National Infrastructure Planning
Temple Quay House
2 The Square
Bristol, BS1 6PN

Our Ref: EN010121

Date: 27 June 2024

Application by Morecambe Offshore Windfarm Ltd for an Order Granting Development Consent for the Morecambe Offshore Windfarm Generation Assets project.

Co-ordinate system: WGS 1984 UTM Zone 30N

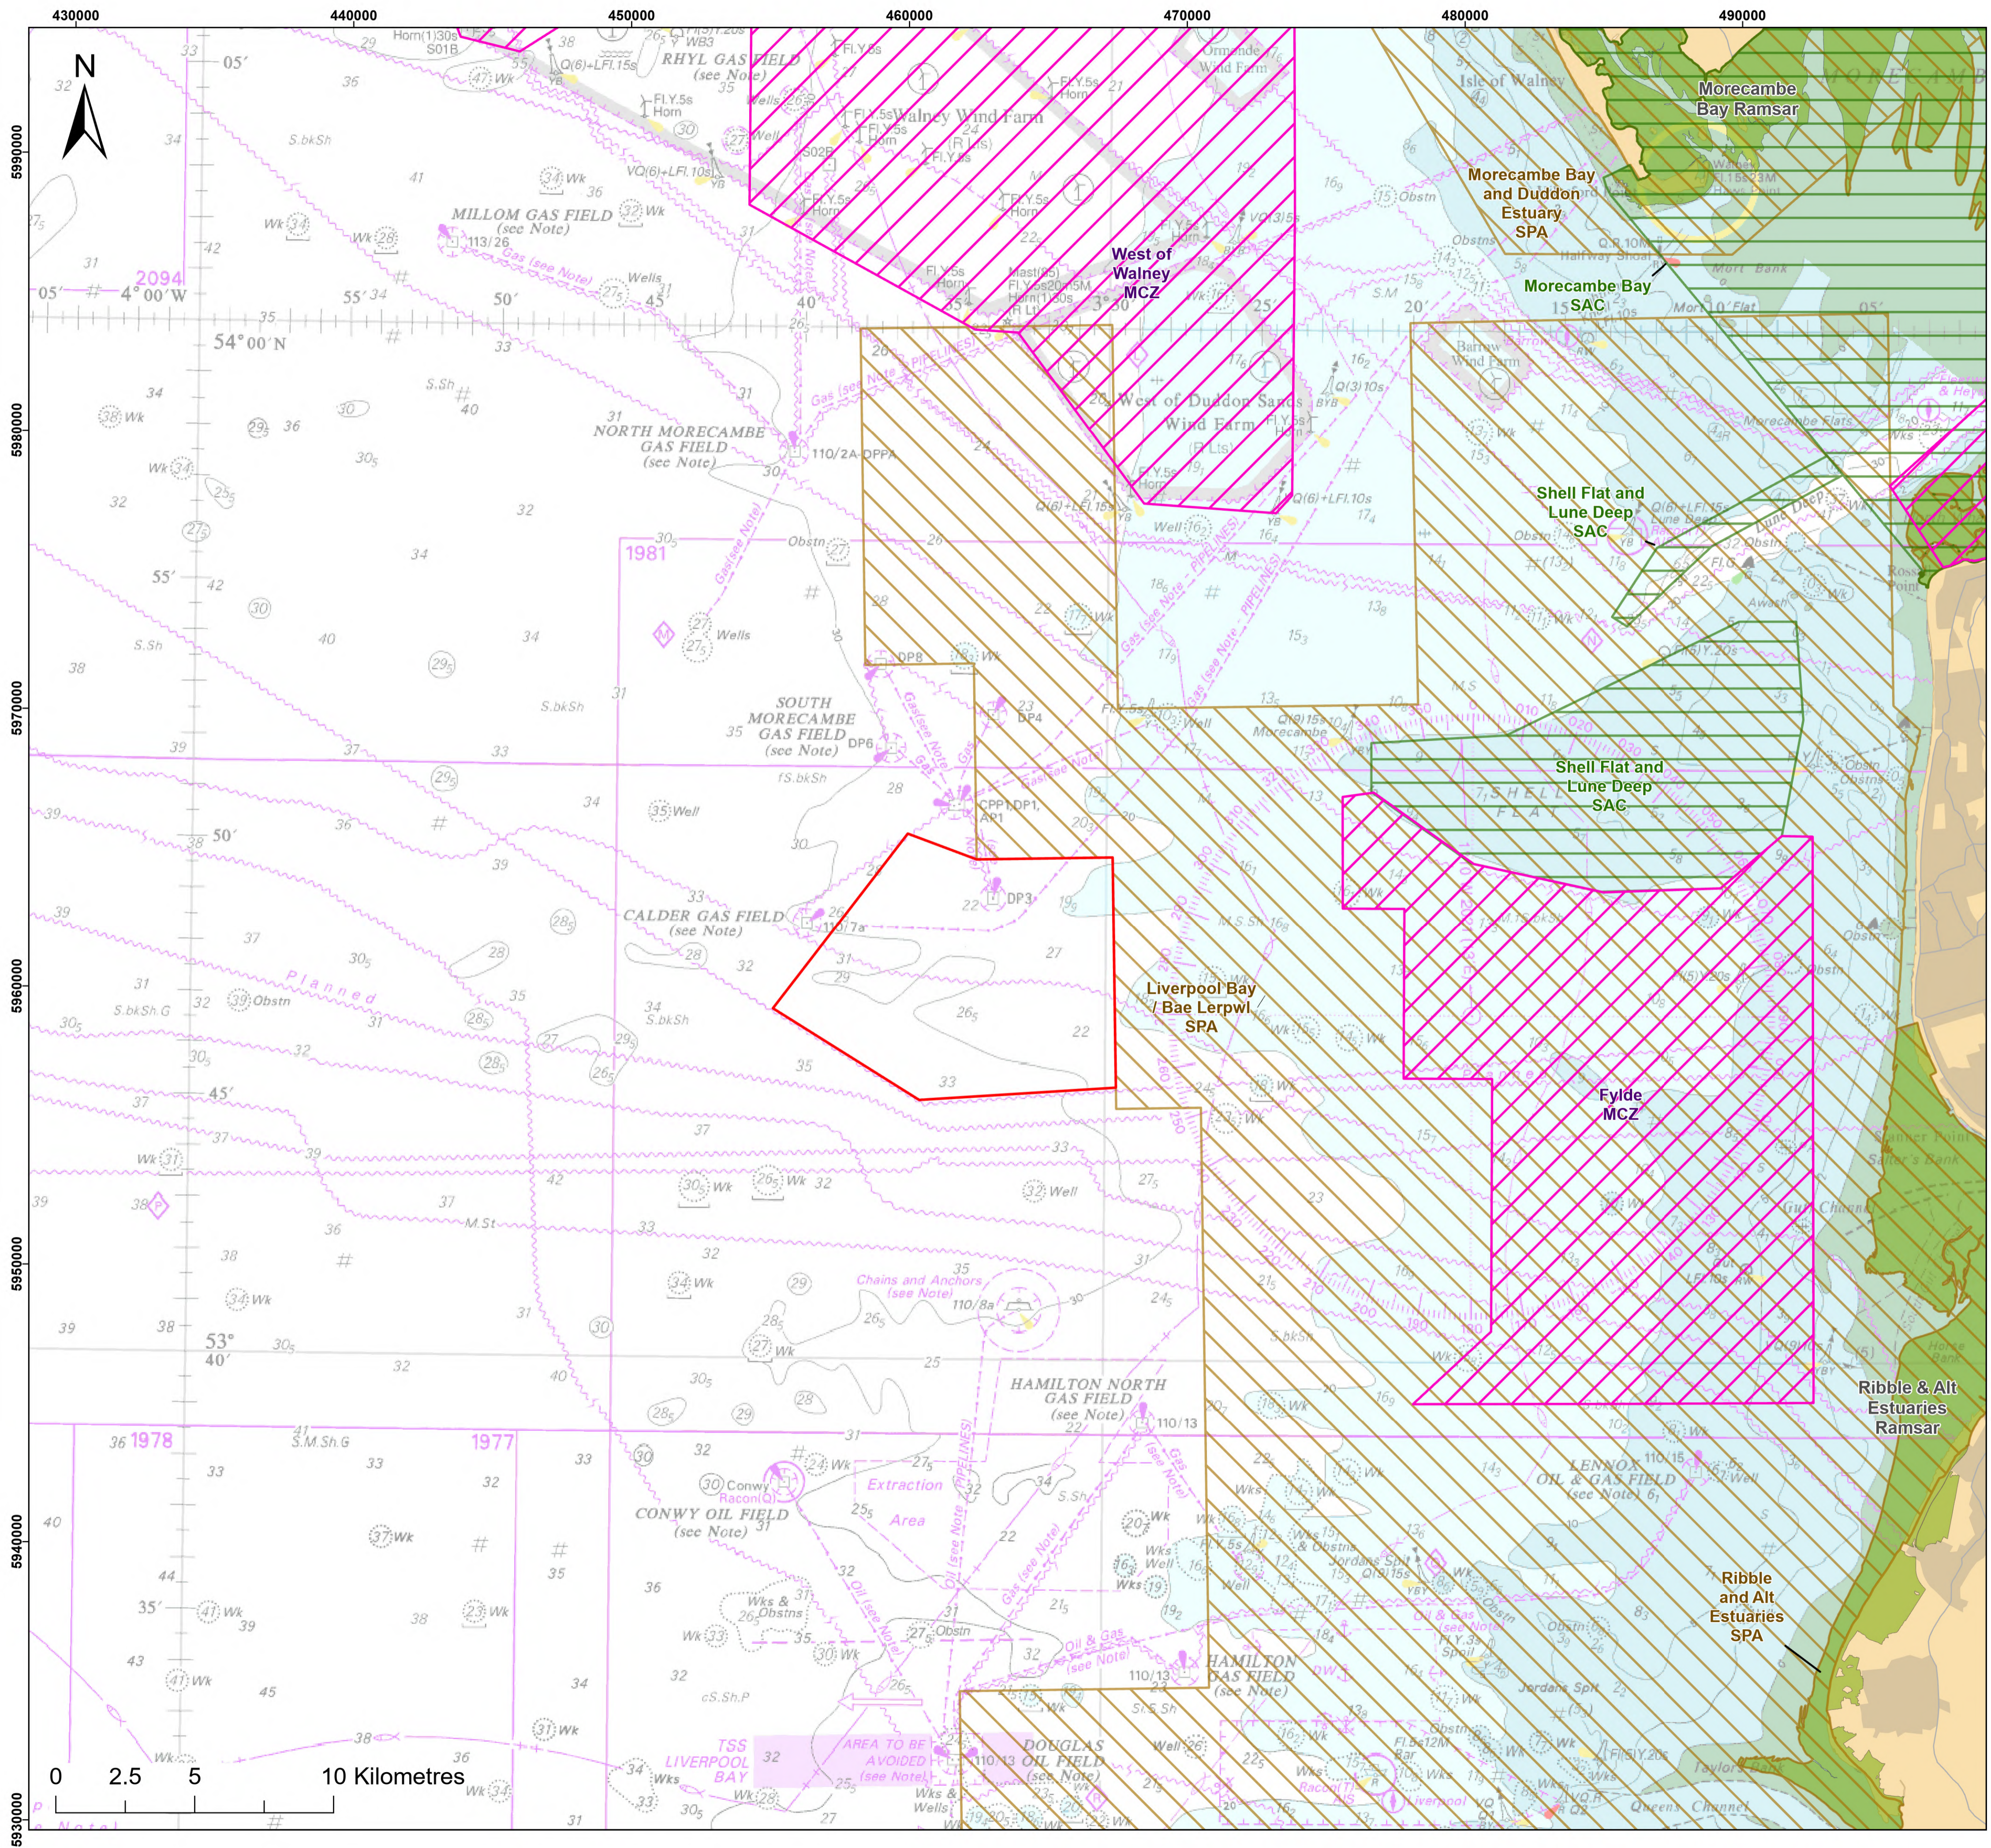
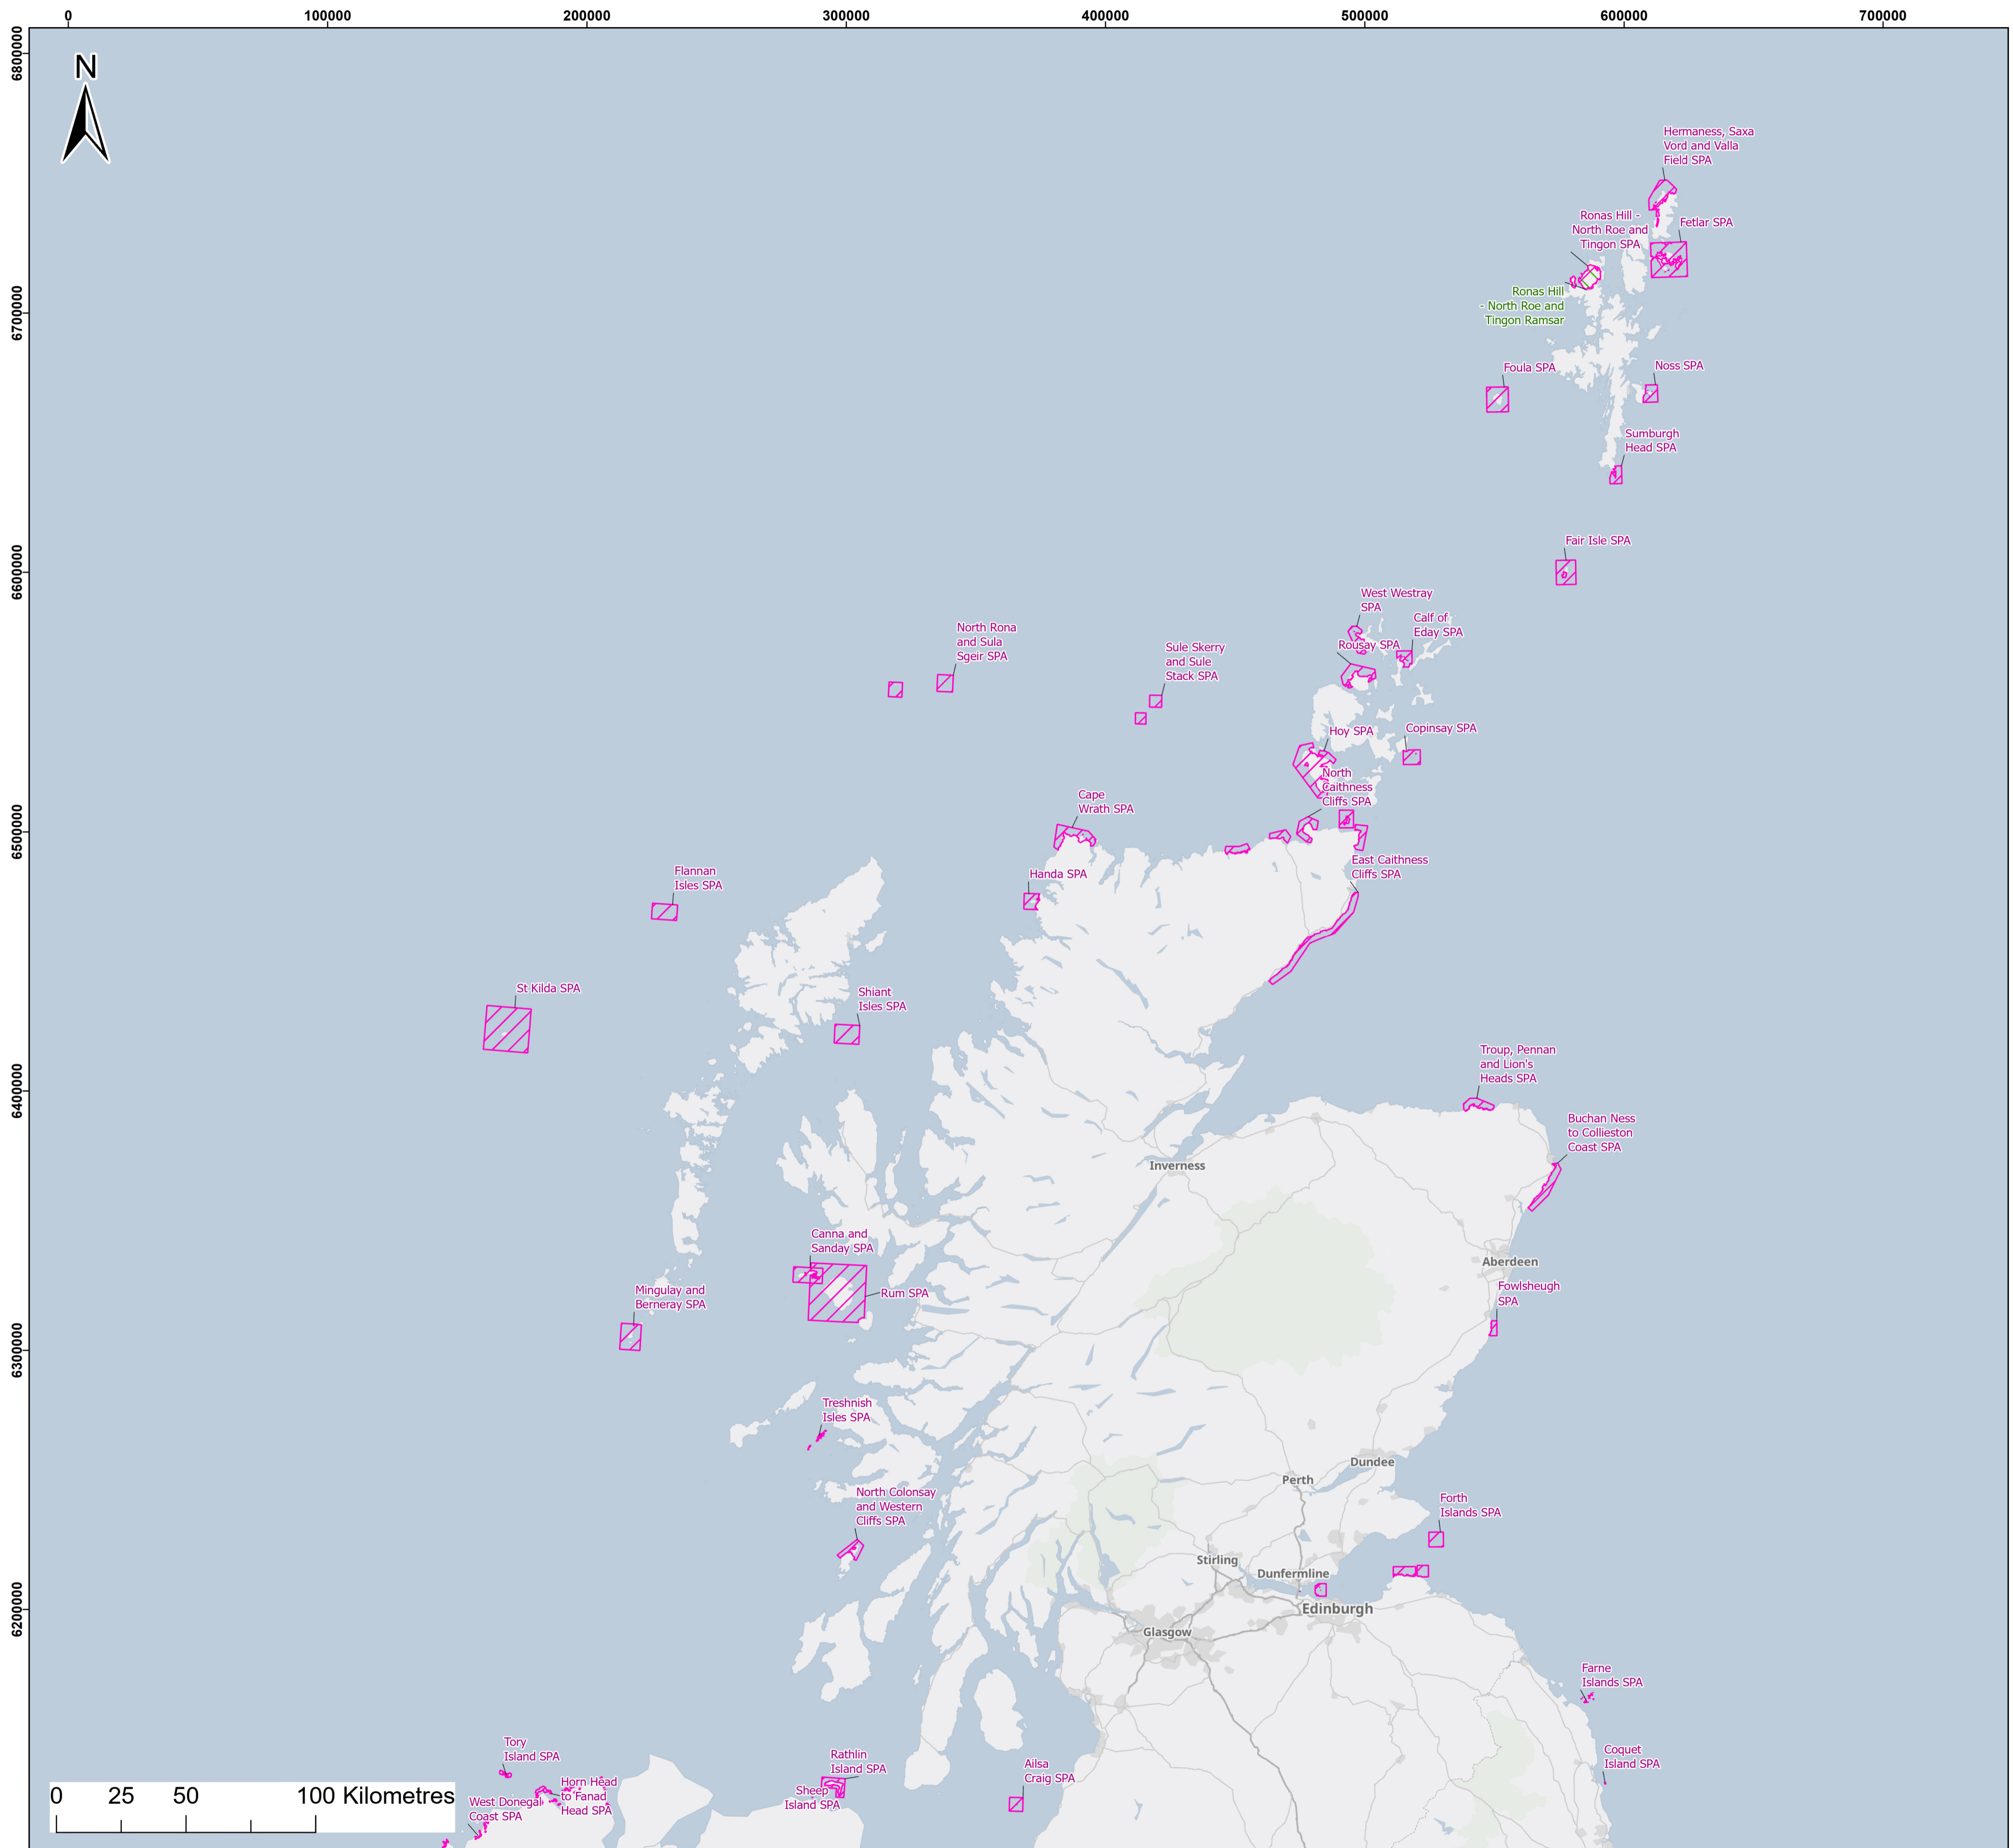
Noting comments in the section 55 checklist, at box 30, the Applicant is requested as soon as possible, to provide the Inspectorate with a plan or a series of plans (noting the

scale required) showing all the statutory and non-statutory designated sites that have been considered as part of the application.
